From: Russell McCourty [REDACTED]
Sent: 12 July 2019 16:15
To: Sian Eggington
Cc: 'Folkes '
Subject: RE: AB/73/19/HH - 50 Torton Hill Road, Arundel
Attachments: 50 Torton Hill Road - 2.01D Proposed Site Plans Shed A1 - Planning Issue.pdf

From: Russell McCourty [REDACTED]
Sent: 12 July 2019 11:50
To: Sian Eggington [REDACTED]
Cc: [REDACTED]
Subject: AB/73/19/HH - 50 Torton Hill Road, Arundel

Proposed Site Plan 1:500

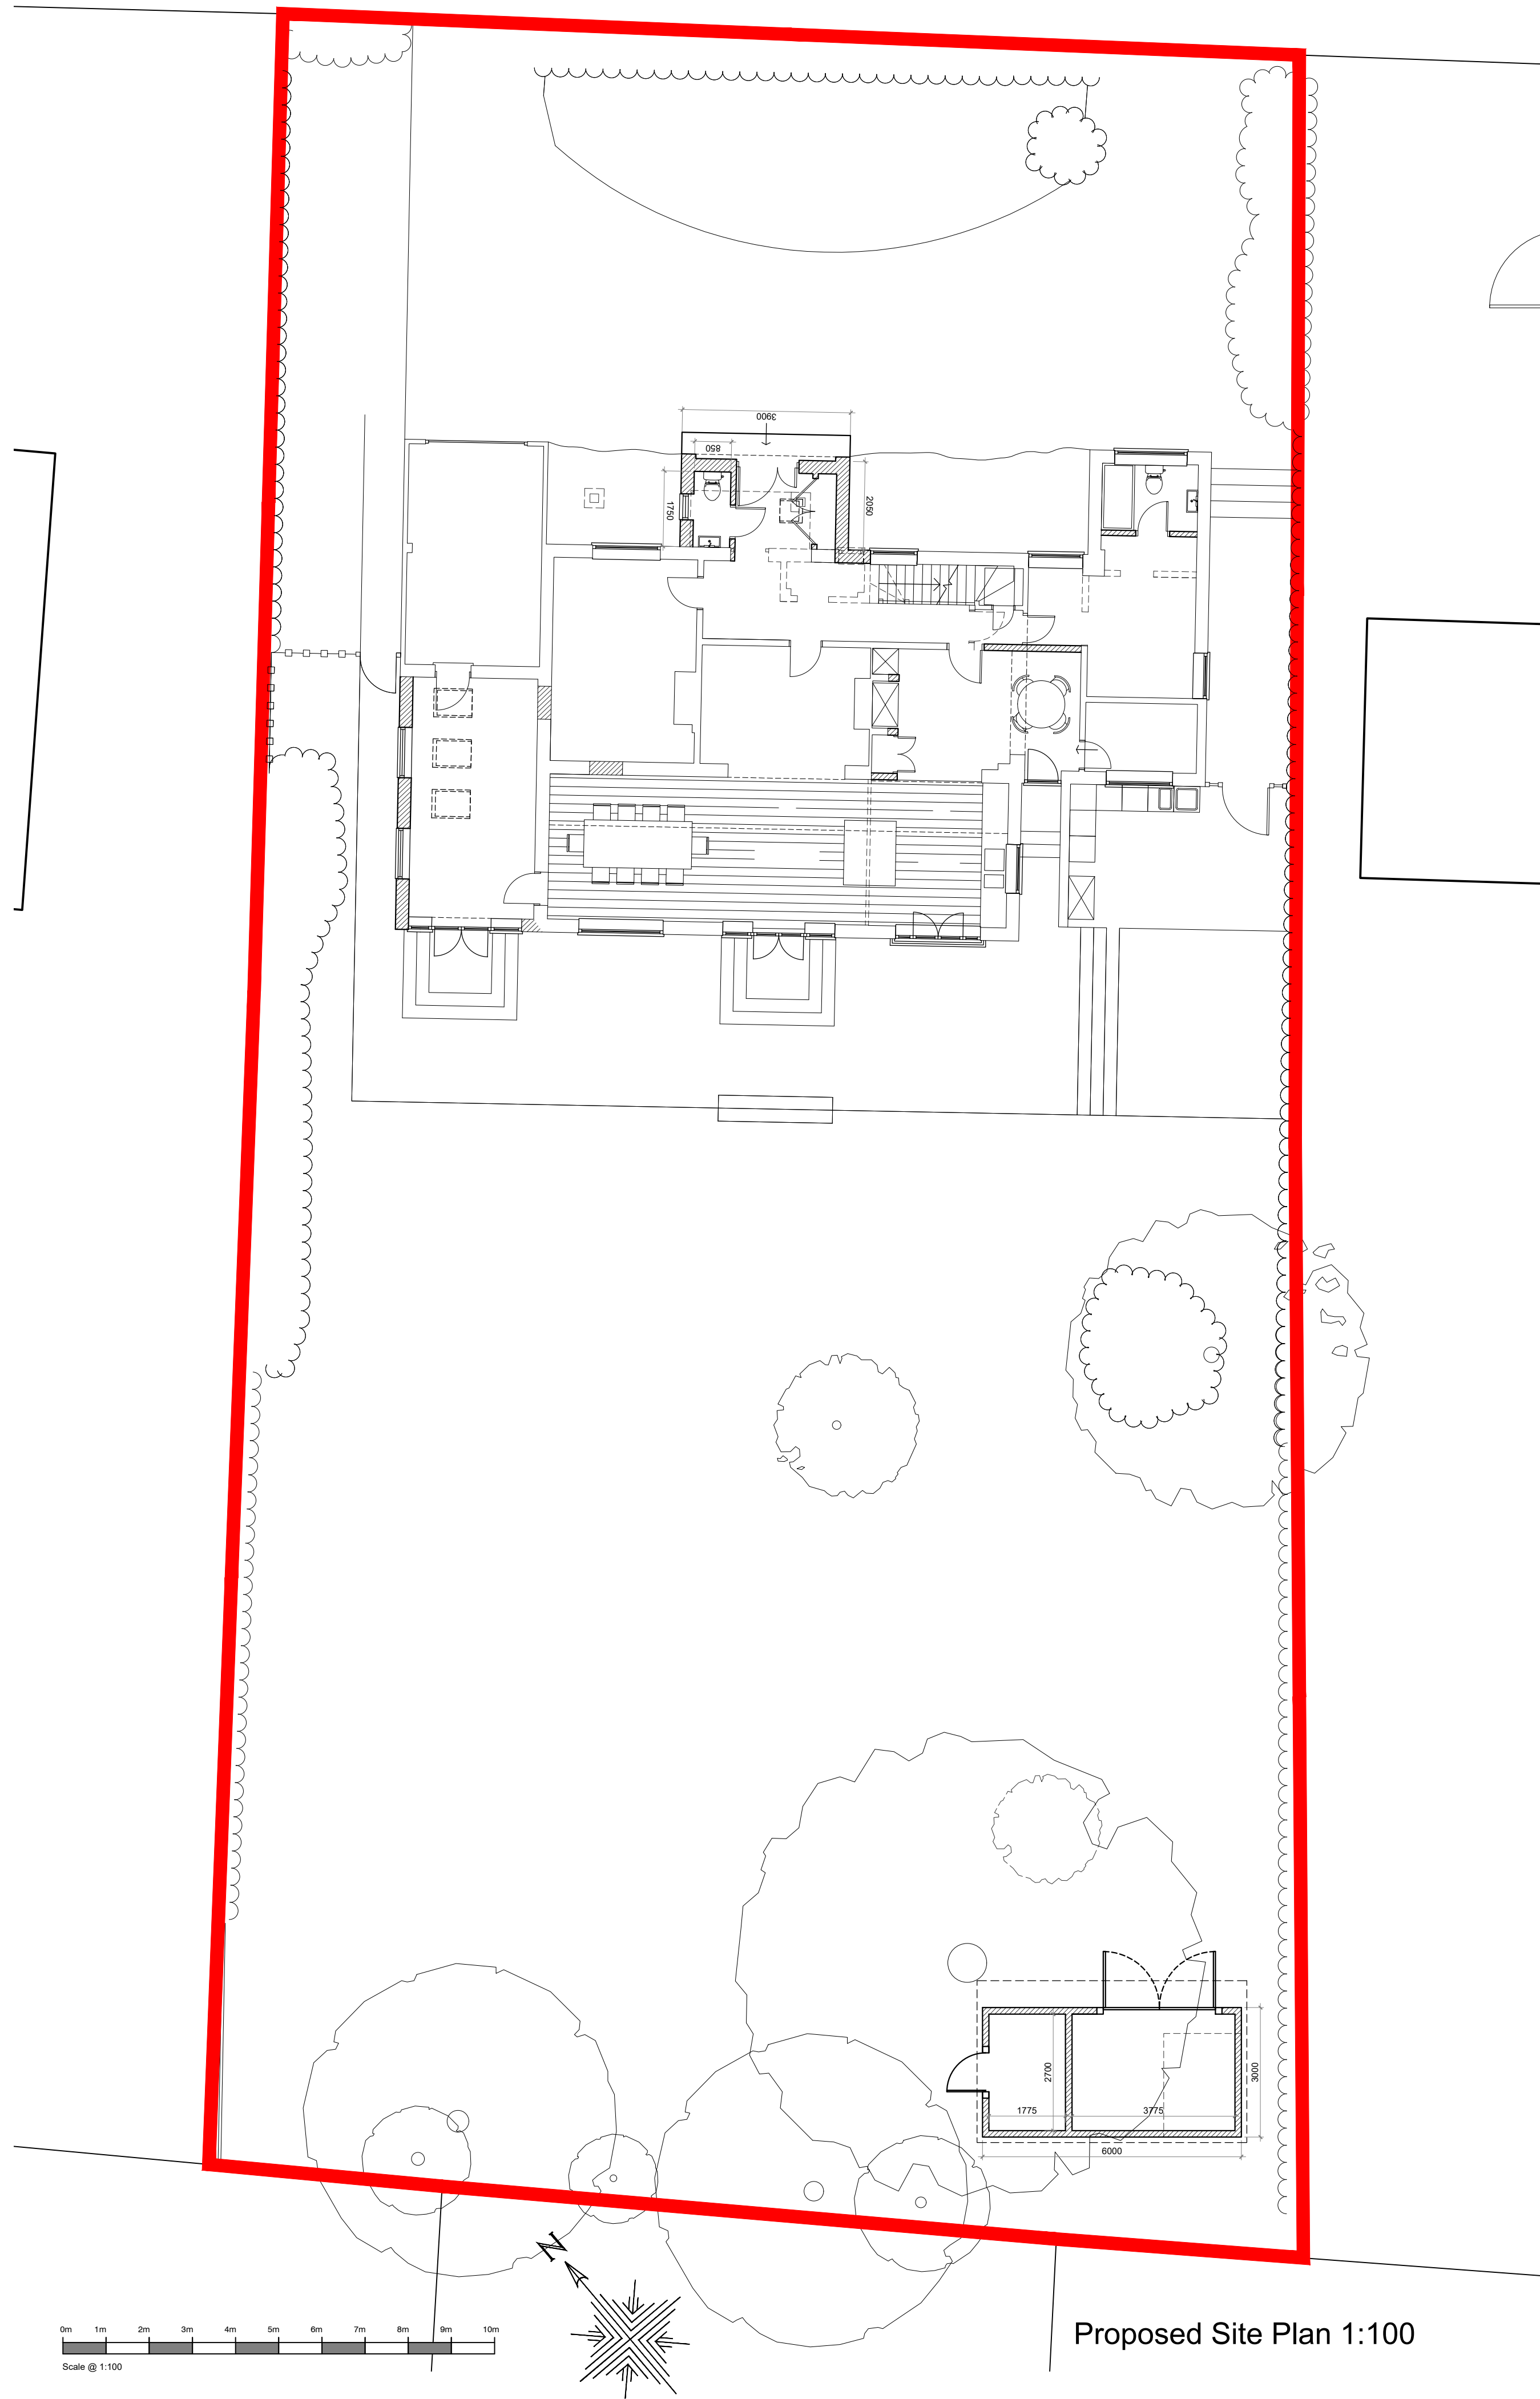
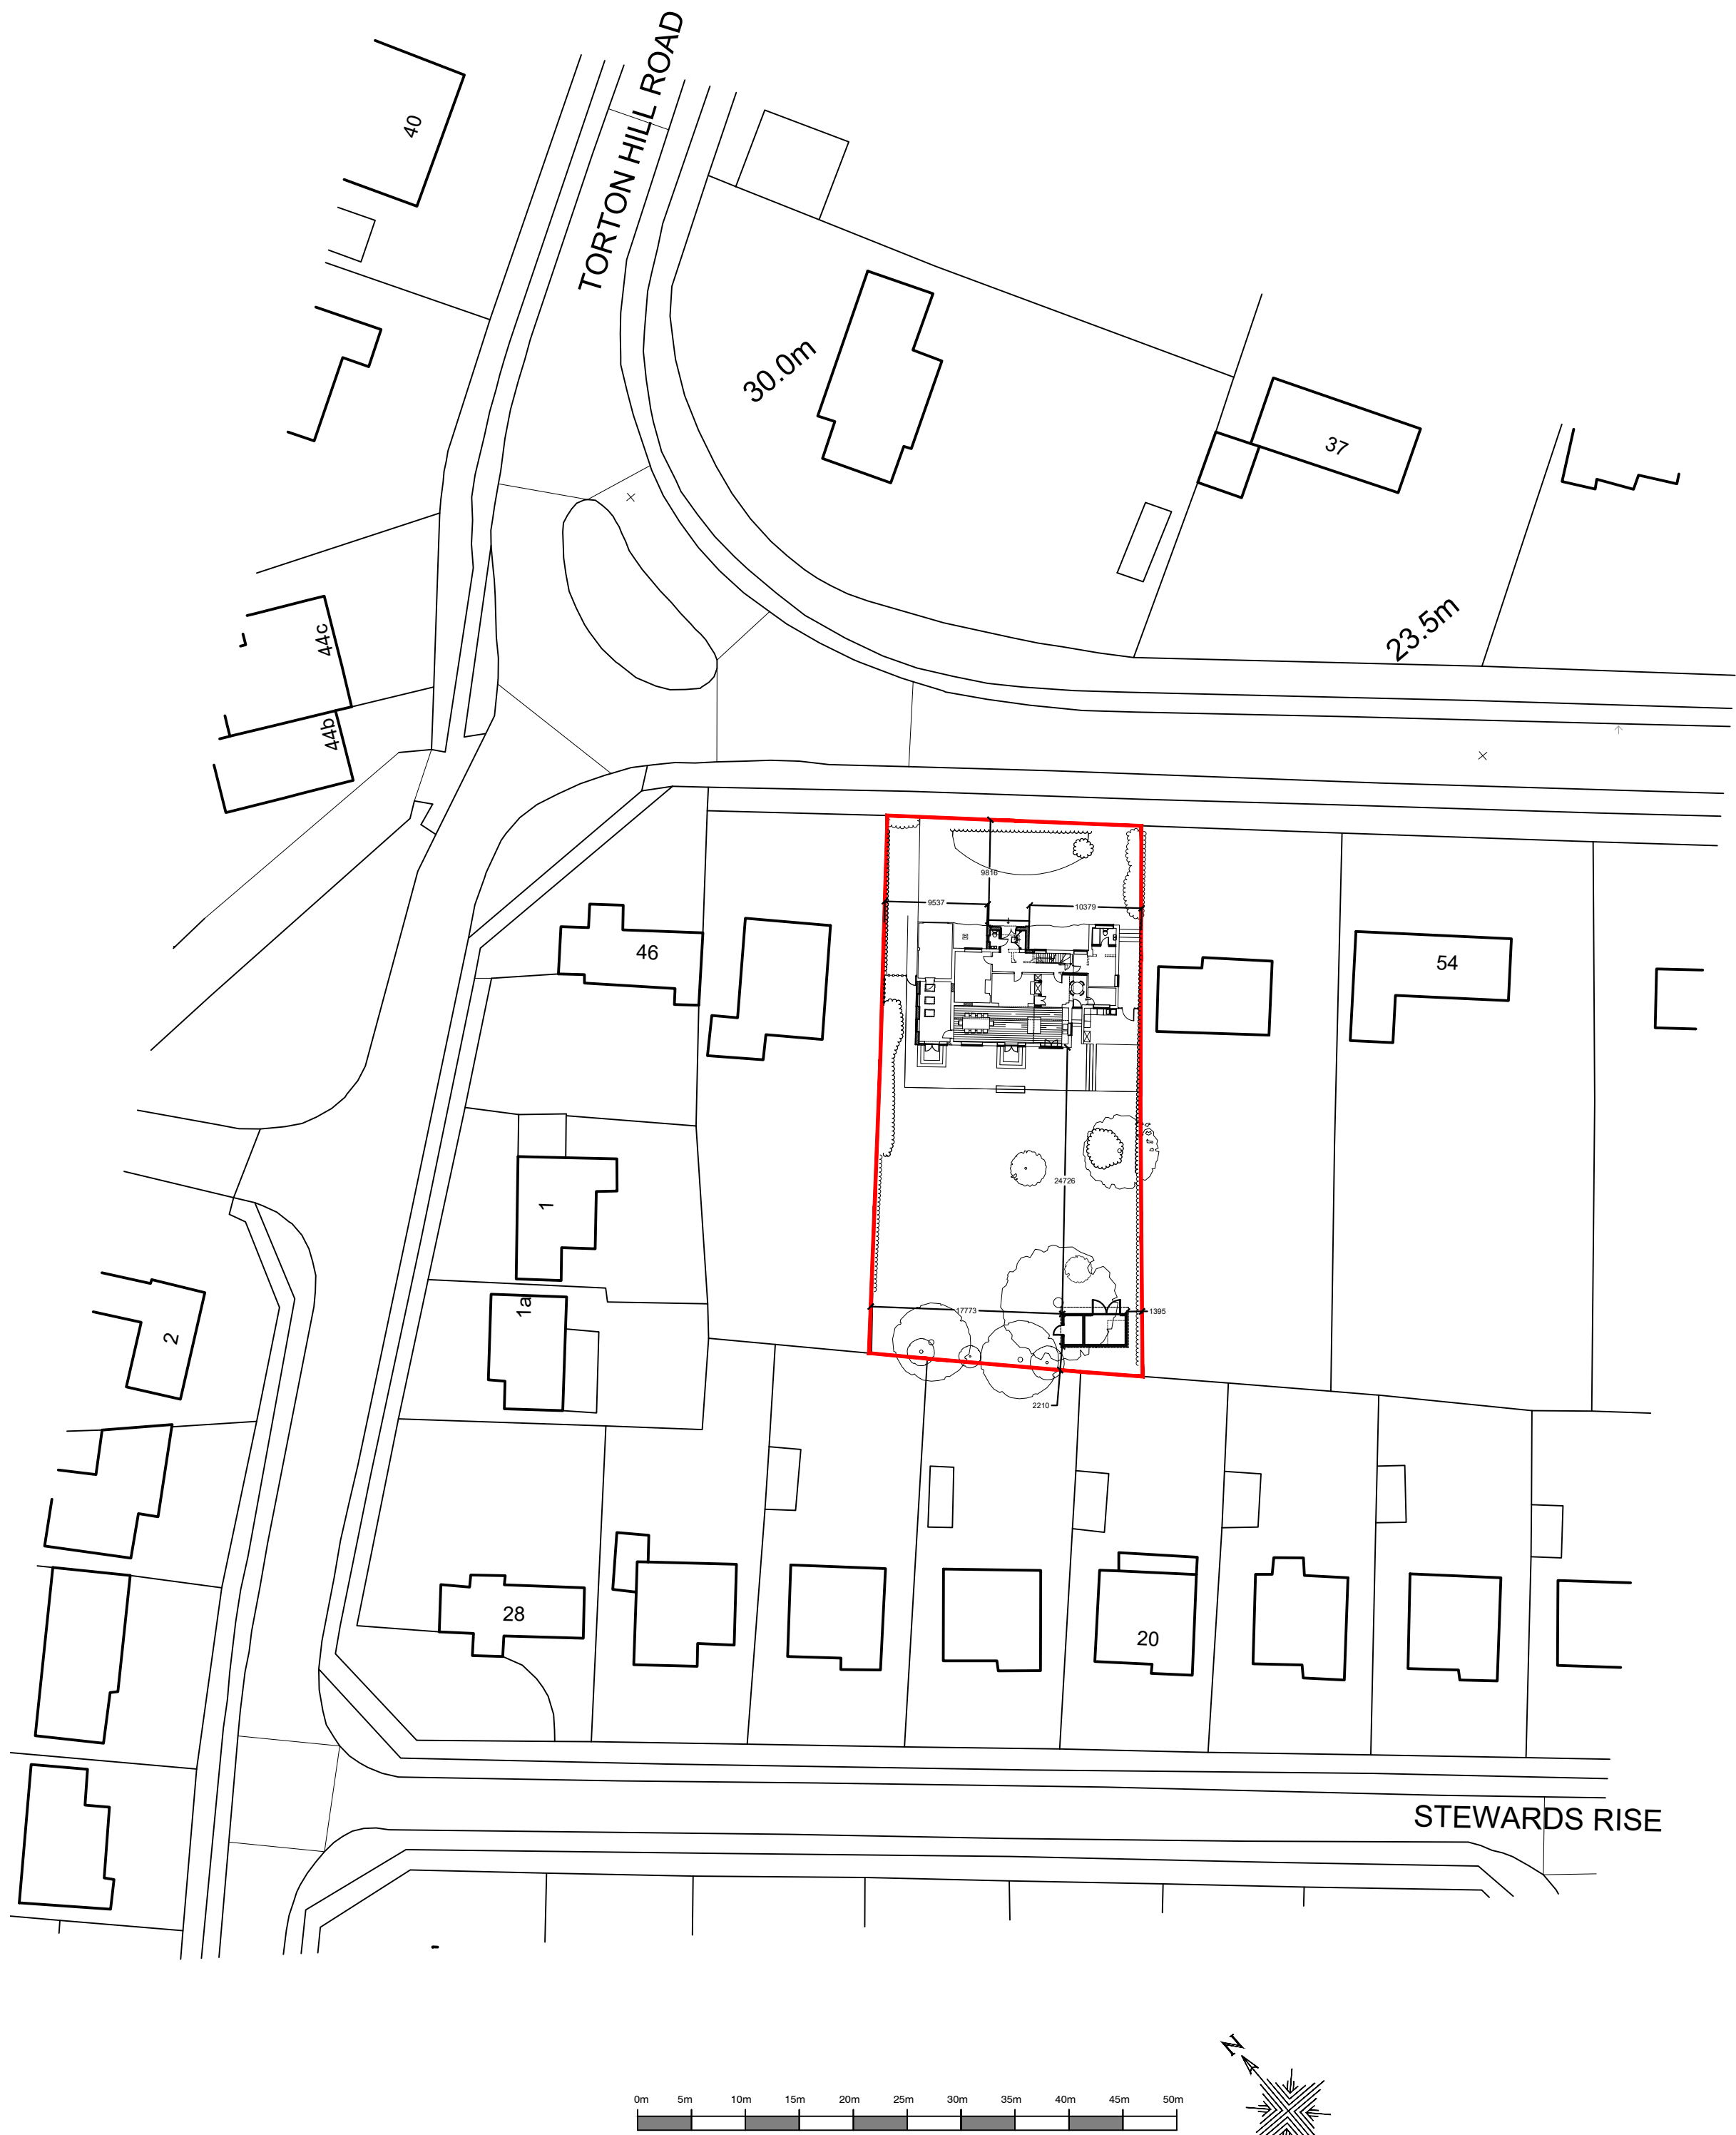
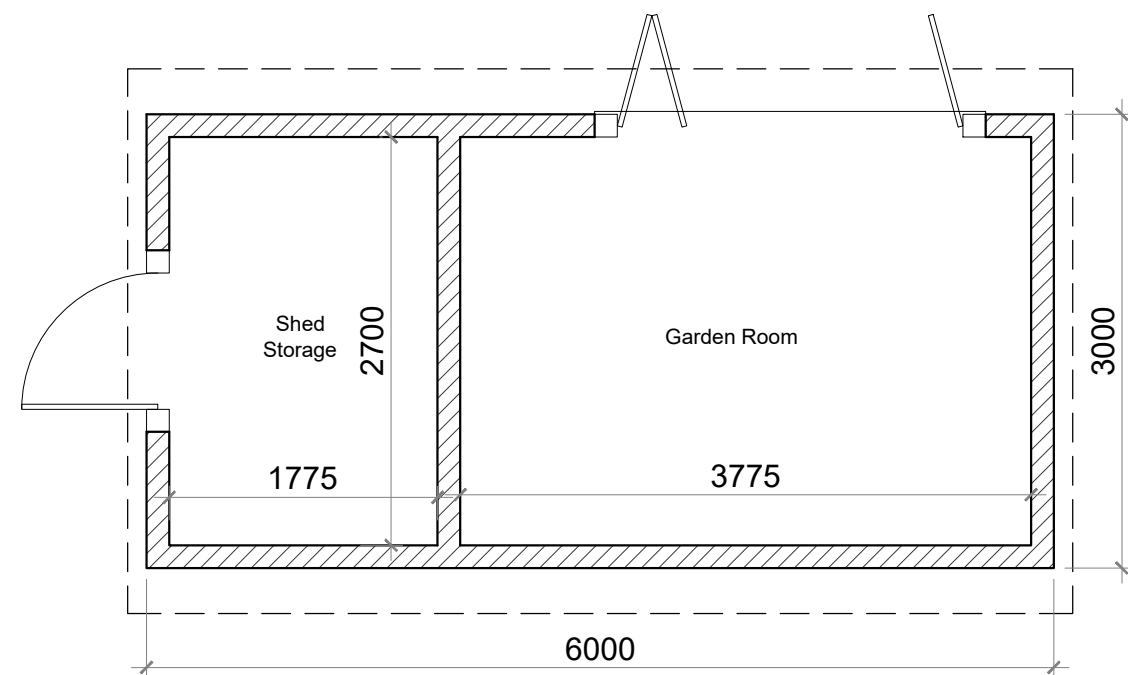
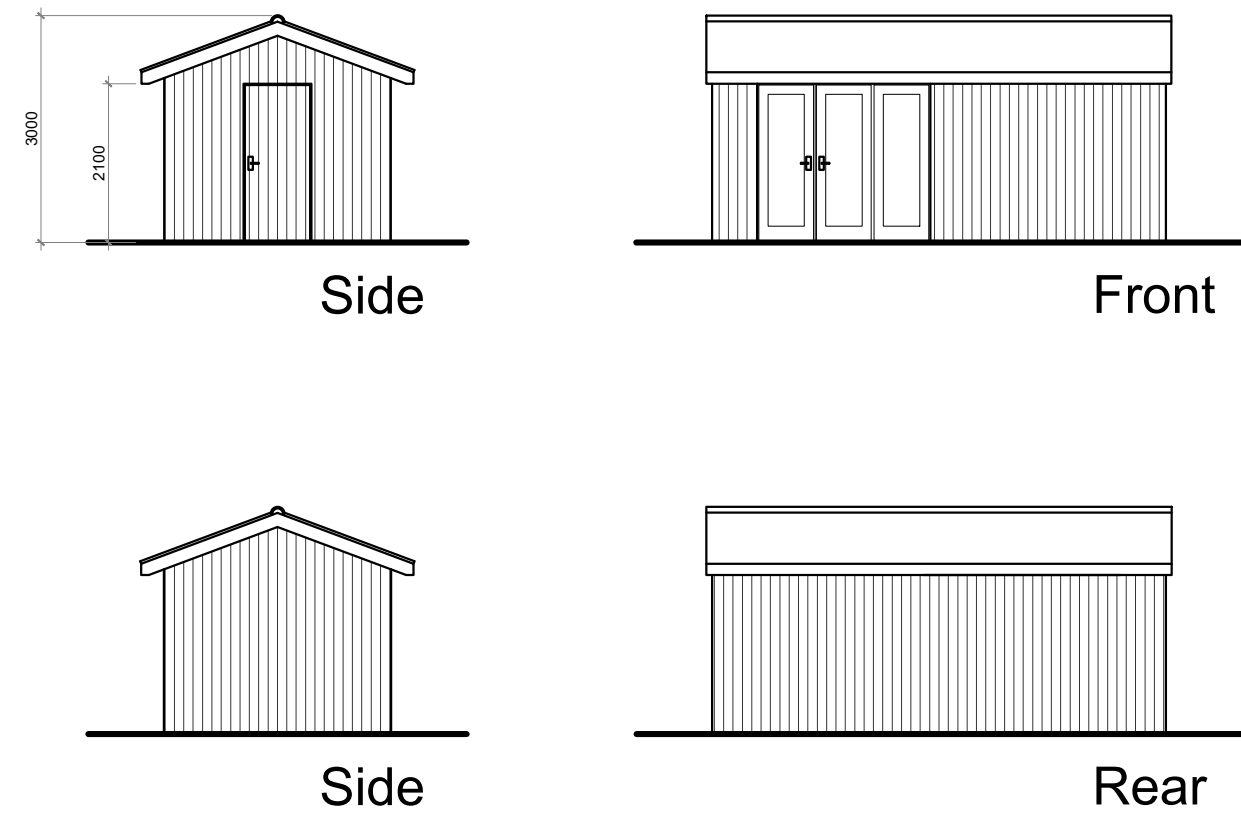
Thank you for your email, however please can you include dimensions from the proposed outbuilding to the site boundaries. However with your permission and if these measurements seem correct to you we can add these to your drawing for you:

OB to side 1- 1.39m
OB to rear 1.48m
OB to other side 17.5m
OB to main dwelling 24.88m

Please find attached the revised proposed drawing with the measurements. The OB to rear measurement is noticeably different, but all others seem roughly the same.
